Application No: P/9/21/HH
Site Address: 9 Kings Drive Pagham PO21 4PY
Description of works: Single storey rear extension with flat roof together with alterations to existing bay windows to the front of the property.

Thank you for your internet representation made on 6th March 2021 which has been recorded as an objection with the comments as follows:

dwg.title As Built Elevations @ A3

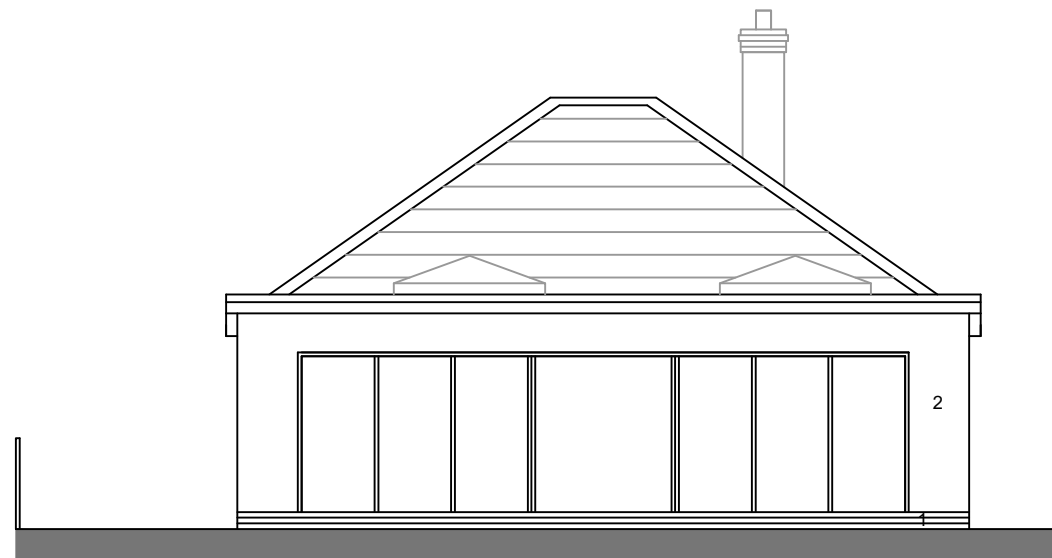
This is a quintessential mid twentieth century bungalow, which has been altered for its development potential, with a total lack of sensitivity to its surroundings. The large extension at the back has been built too high and does not flow into the main section of the bungalow. It appears to have been built to maximise internal space at the expense of aesthetic merit. Although the extension is at the rear of the property, it can be clearly seen from the street view and appears dominant. The removal of the bay windows and the flattening of the front facade is unfortunate and totally out of character with the surrounding 1950's and 1920's bungalows which still retain their period features and charm.
